From:
Sent: 06 July 2026 12:24
To: Katie Chew
Cc: DC Admin
Subject: Clarification required regarding application 2026/91657

I am writing regarding application **2026/91657** for Plot 23.

The application appears to be described as adding a double garage. However, the submitted drawing **SK15 Rev B** appears to show other matters as well.

Rev B	03/06/2026	Updated for planning submission.		
Rev A	24/09/2025	Minor amendments, dimensions added.		
Project :		Housing at Lingards Road, Slaithwaite.		
Client :		SB Homes.		
Drawing :		Plot 23 - OPTION 1.		
Scale :		1:100.	Date :	May 2025
Dwg No :		2019 572 Sk 15	Rev :	B

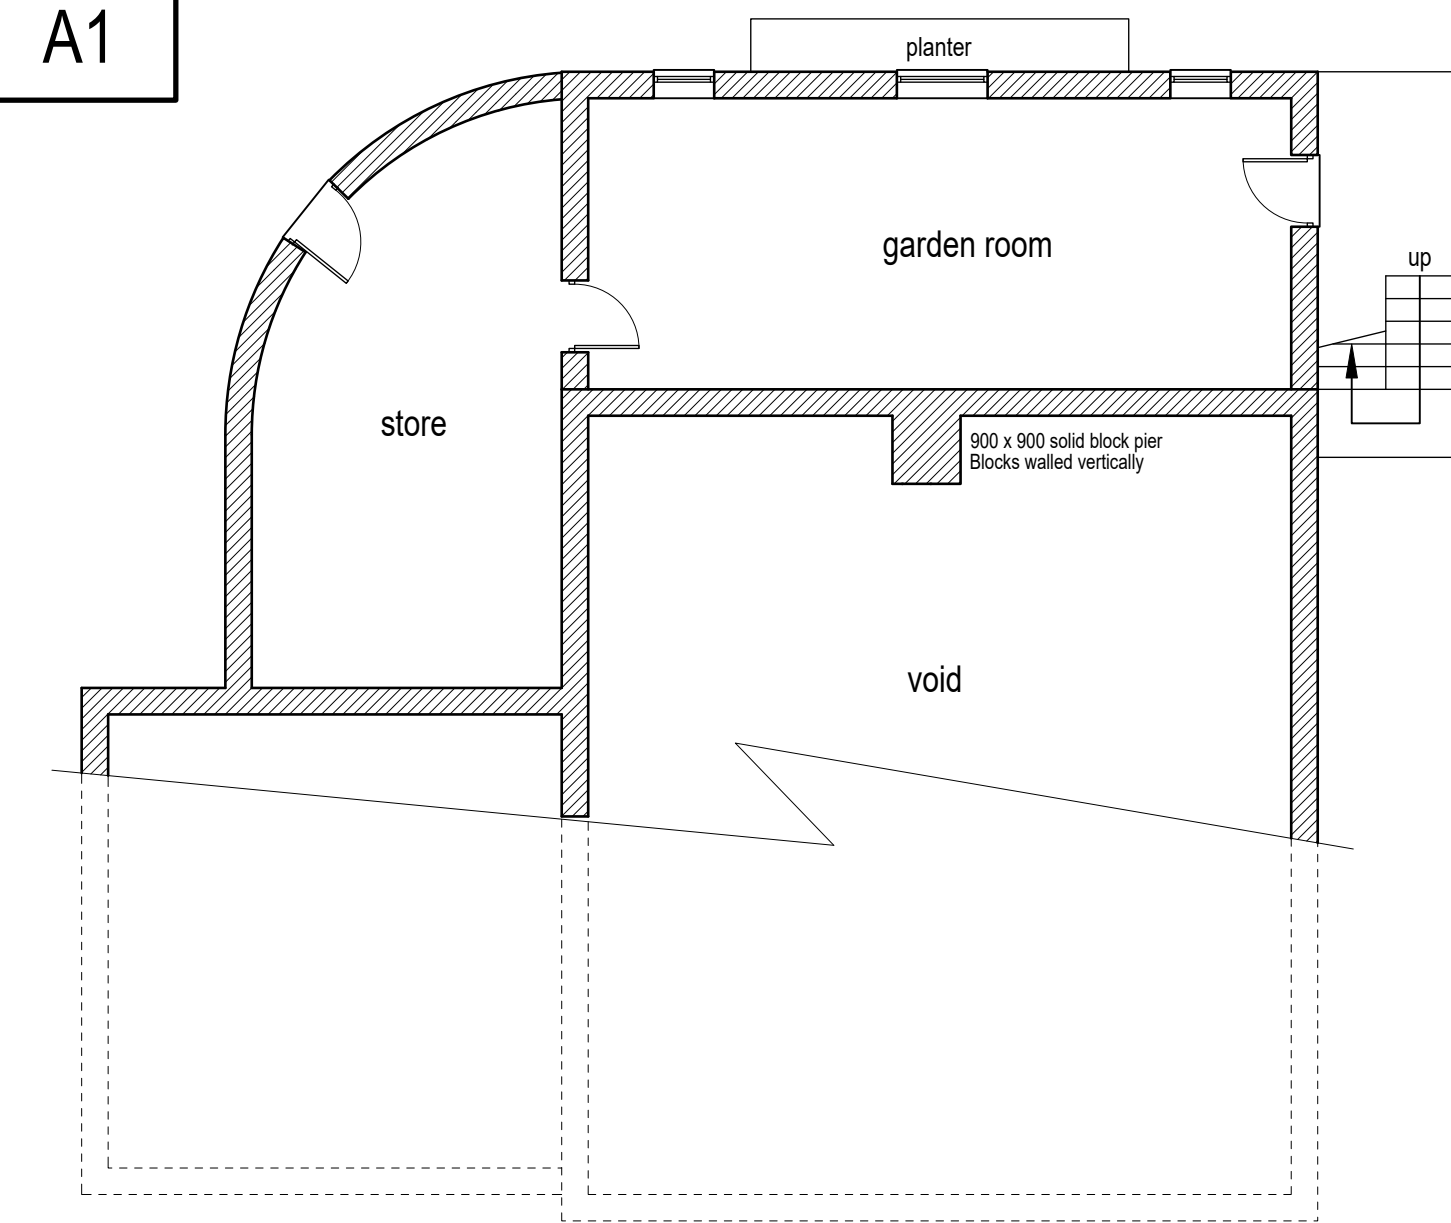
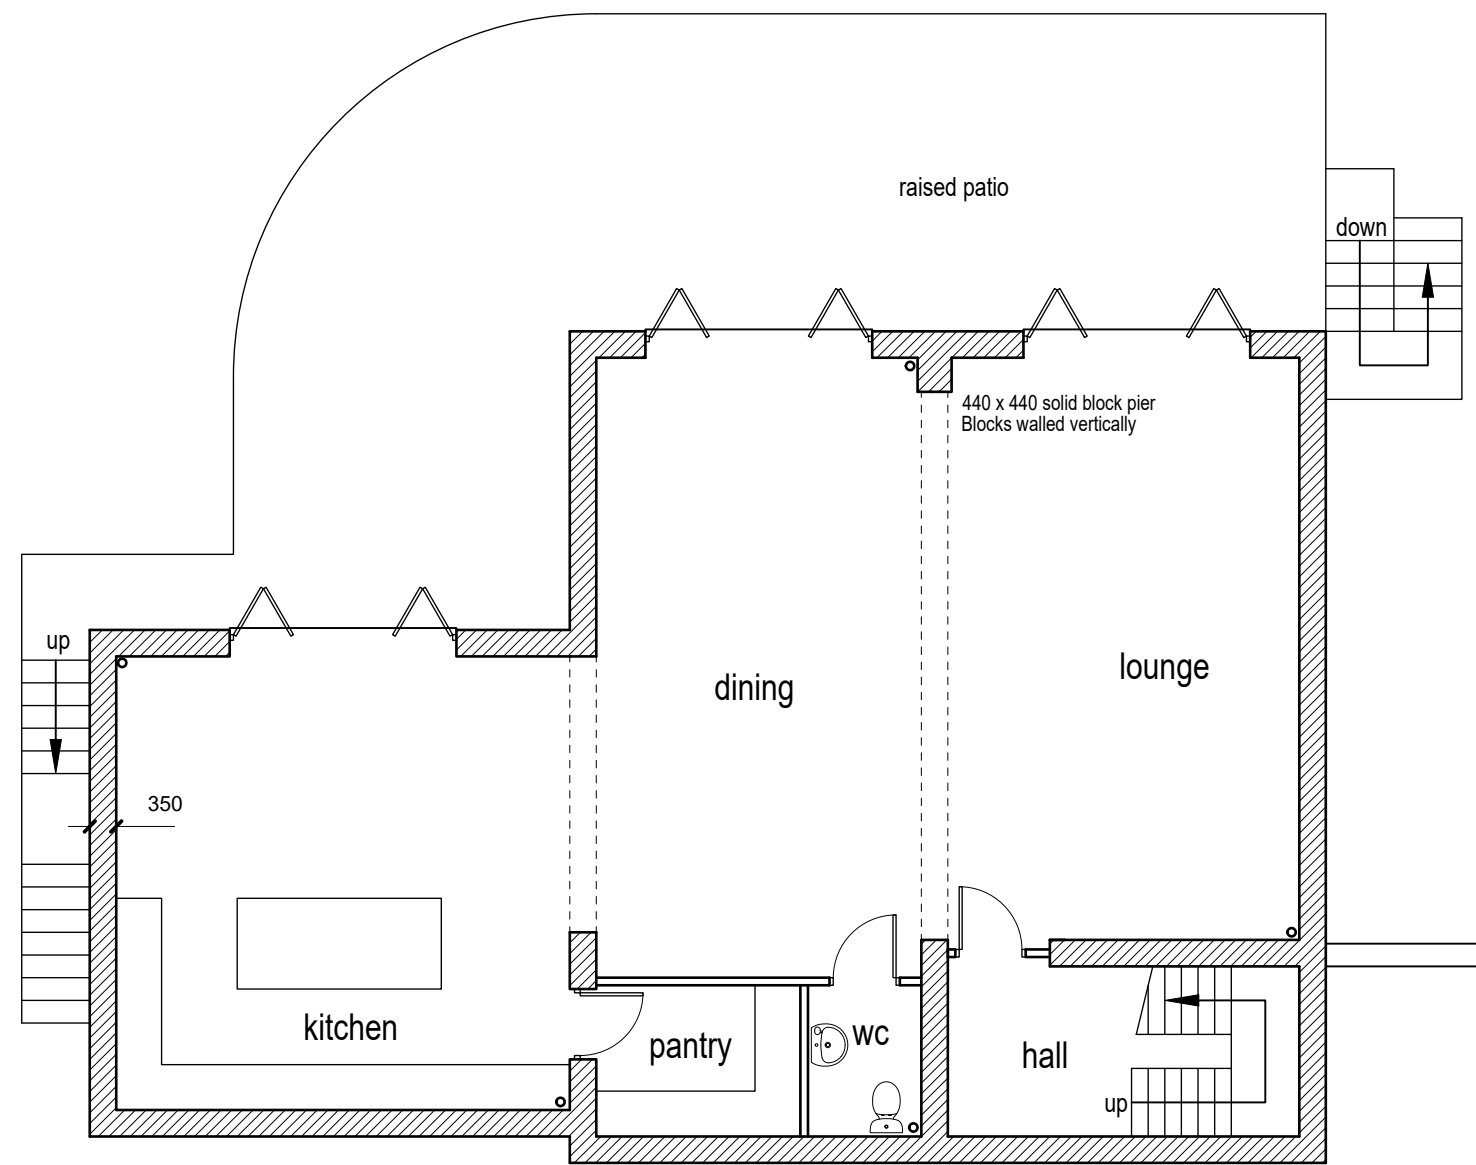
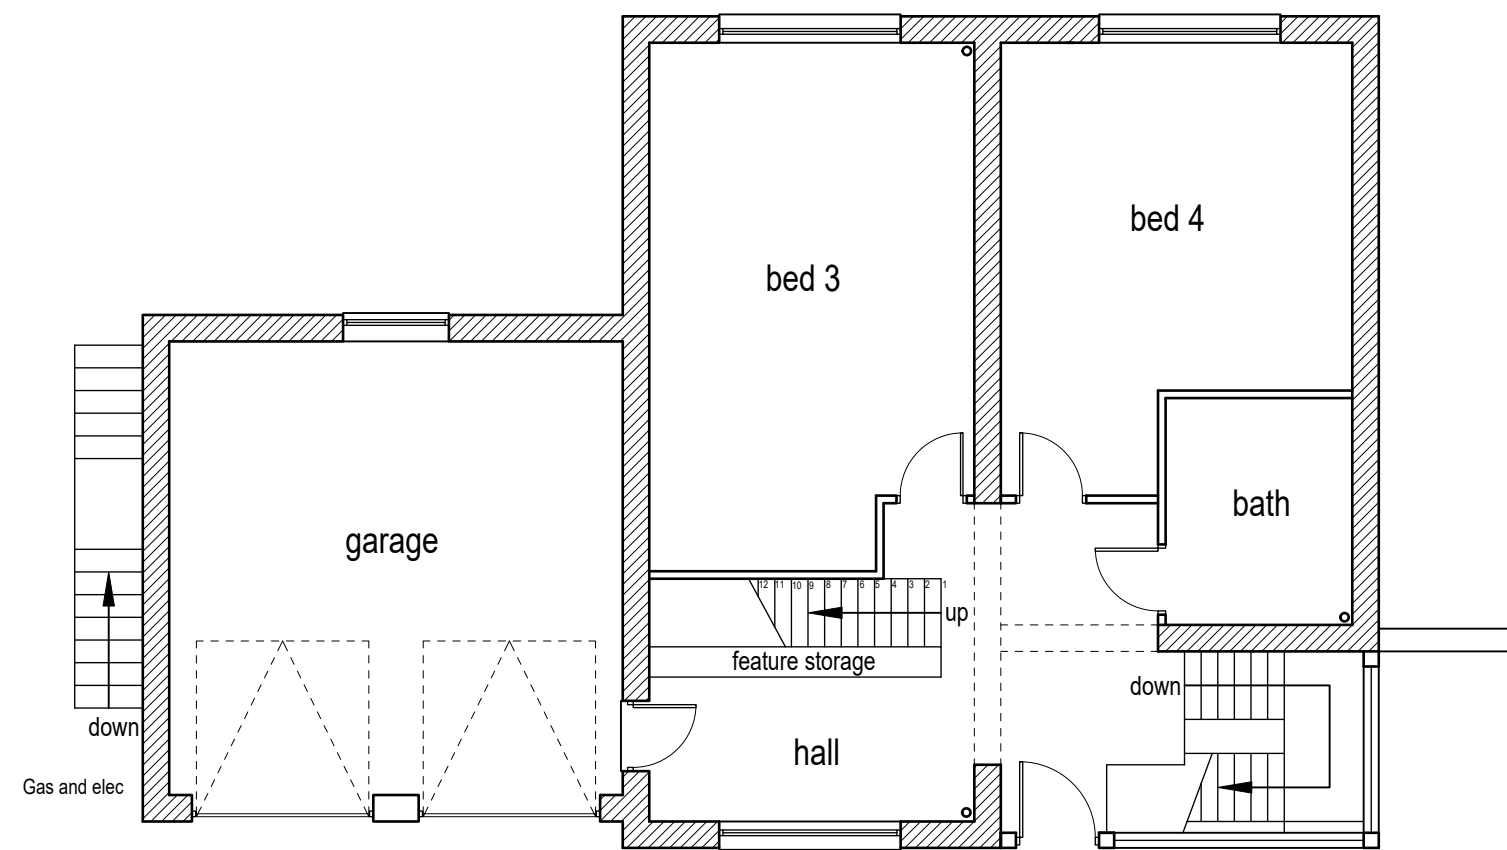
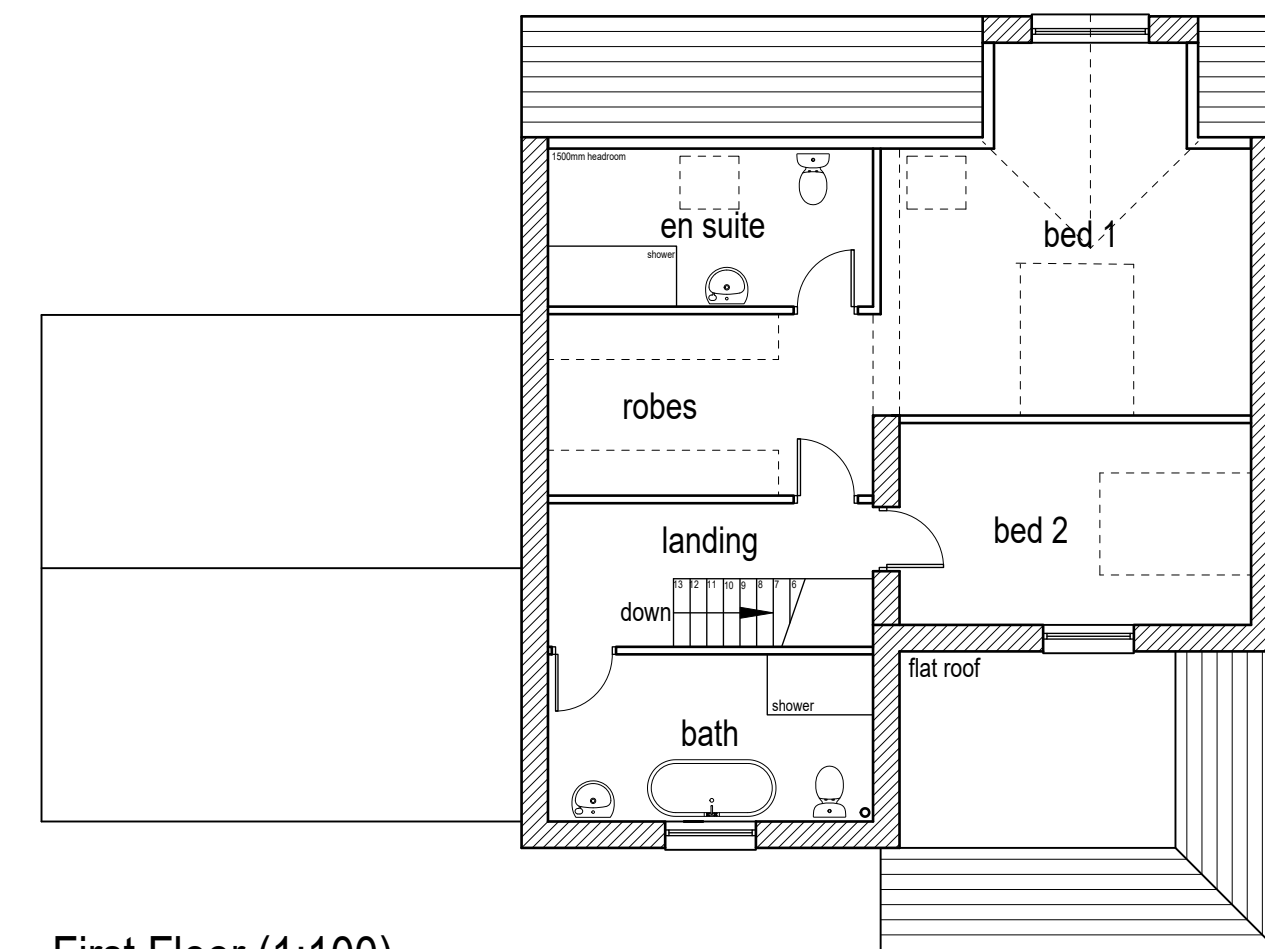
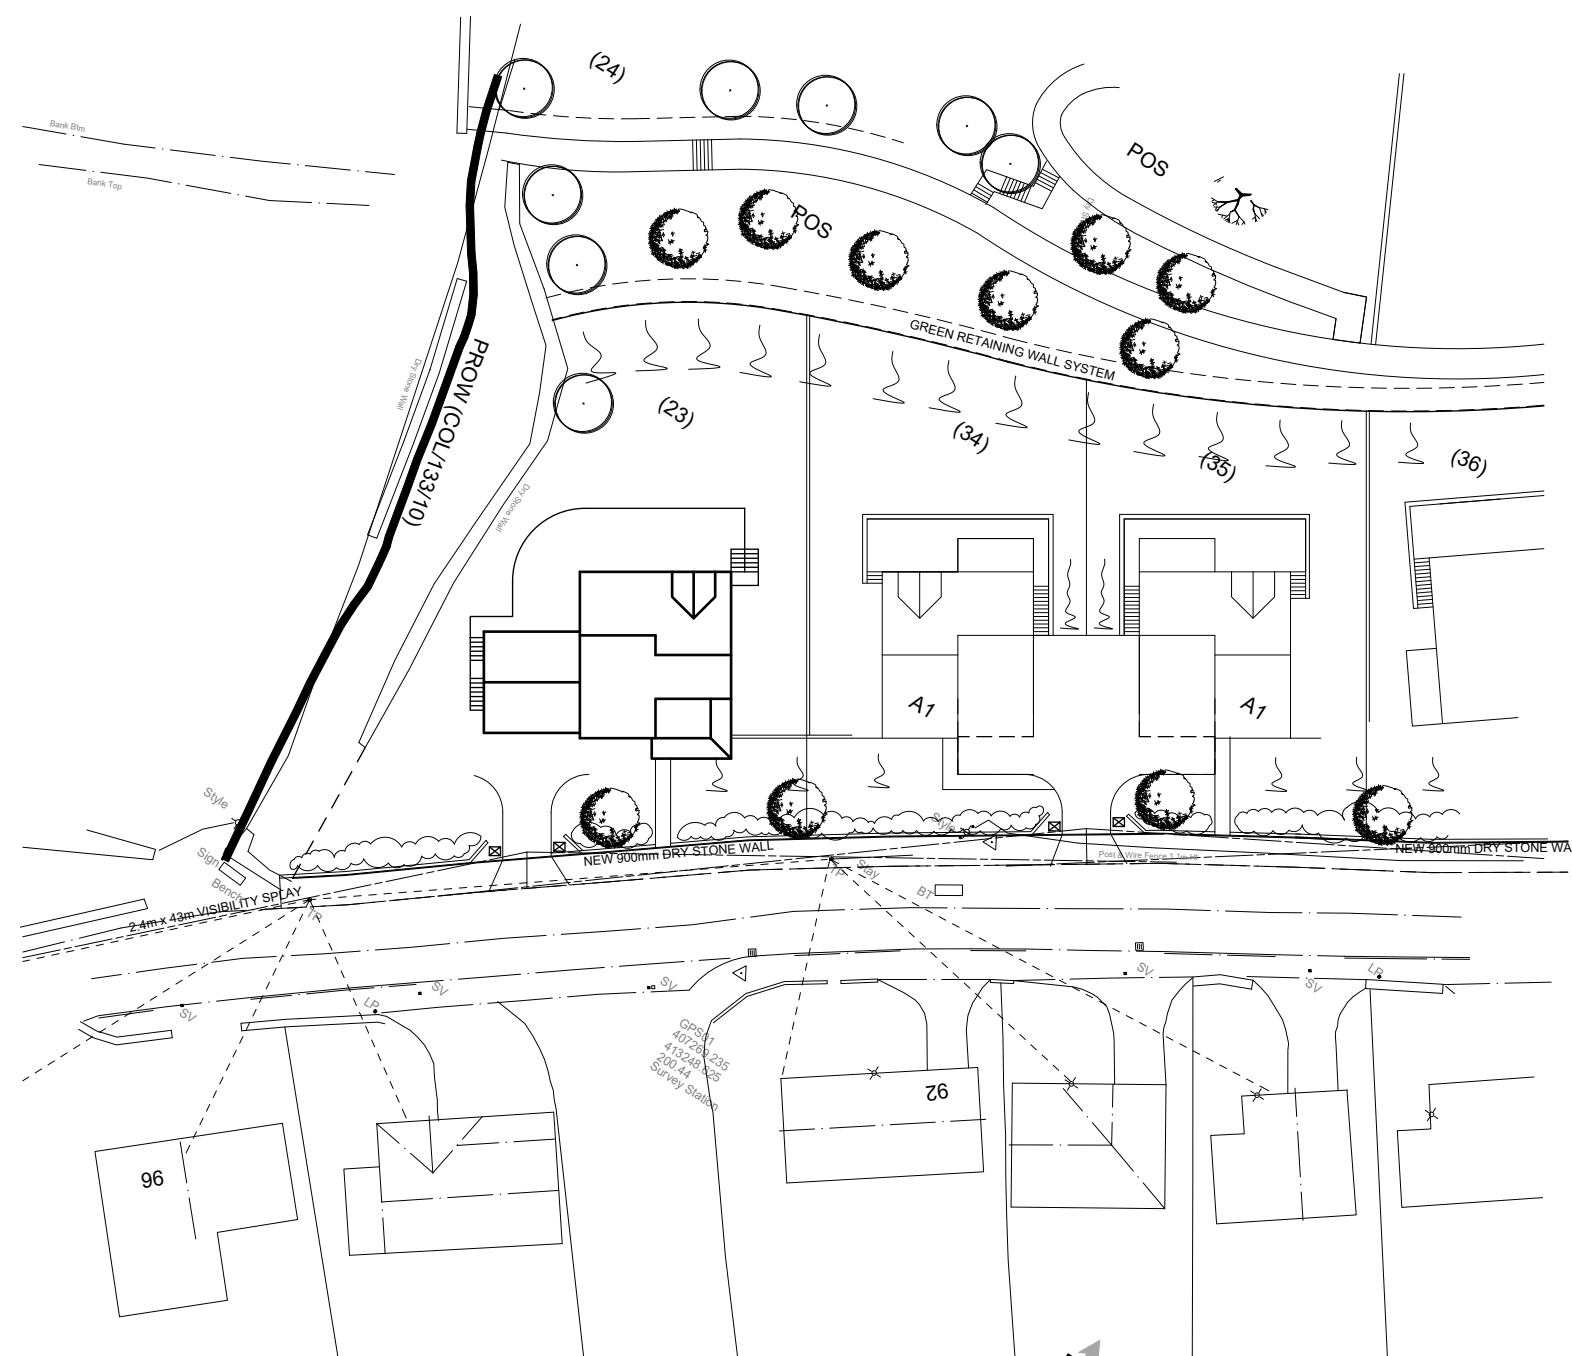
1. a **garage-only amendment**; or
2. an application to approve **everything shown on SK15 Rev B**, including any non-garage changes?

This clarification is important because, if SK15 Rev B is approved under Condition 2, I am concerned that all changes shown on that drawing may be treated as approved, not just the garage.
